TO: All Staff
FROM: Justin Turnbull, County Surveyor *ST*
DATE: July 26, 2017
SUBJECT: County Survey Review of Boundary Line Adjustment 17-00008 (Kachess)

Suggested Changes (not required)

**GARDINIER PROPERTY**

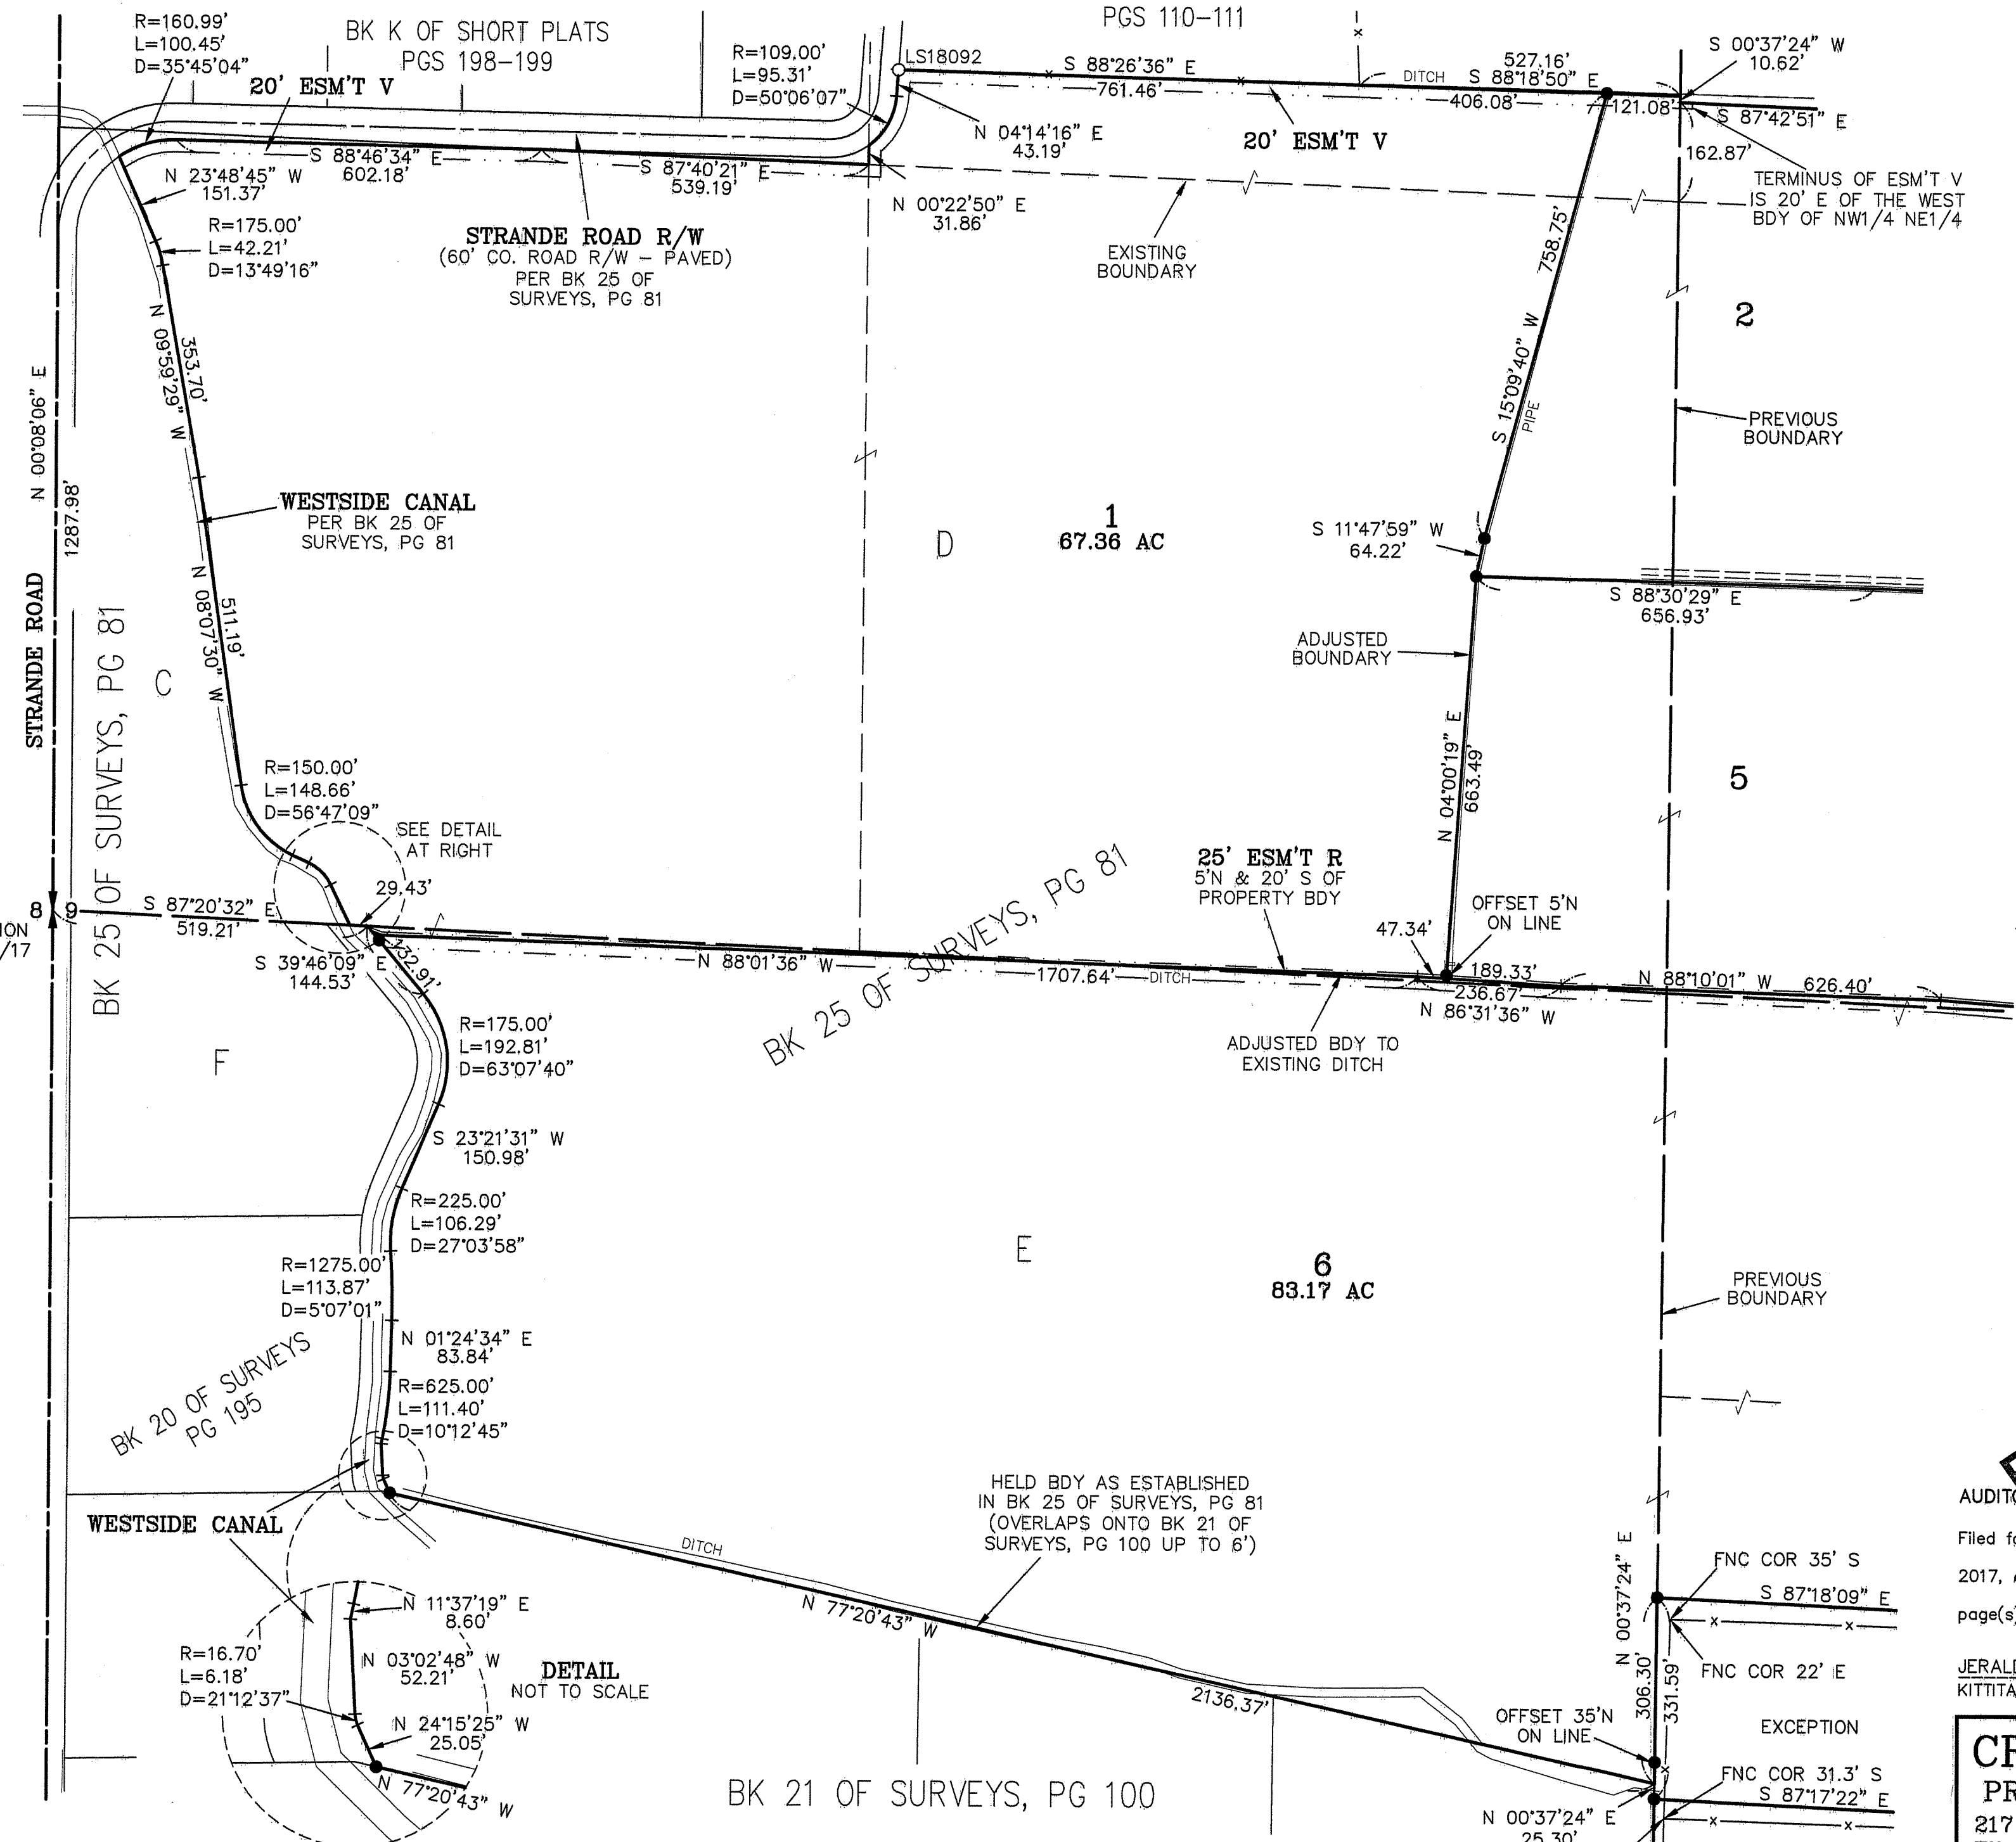
1. All easements should be labeled as "Existing", or "Created via Separate Document"(or similar). All easements should width and type of easement.
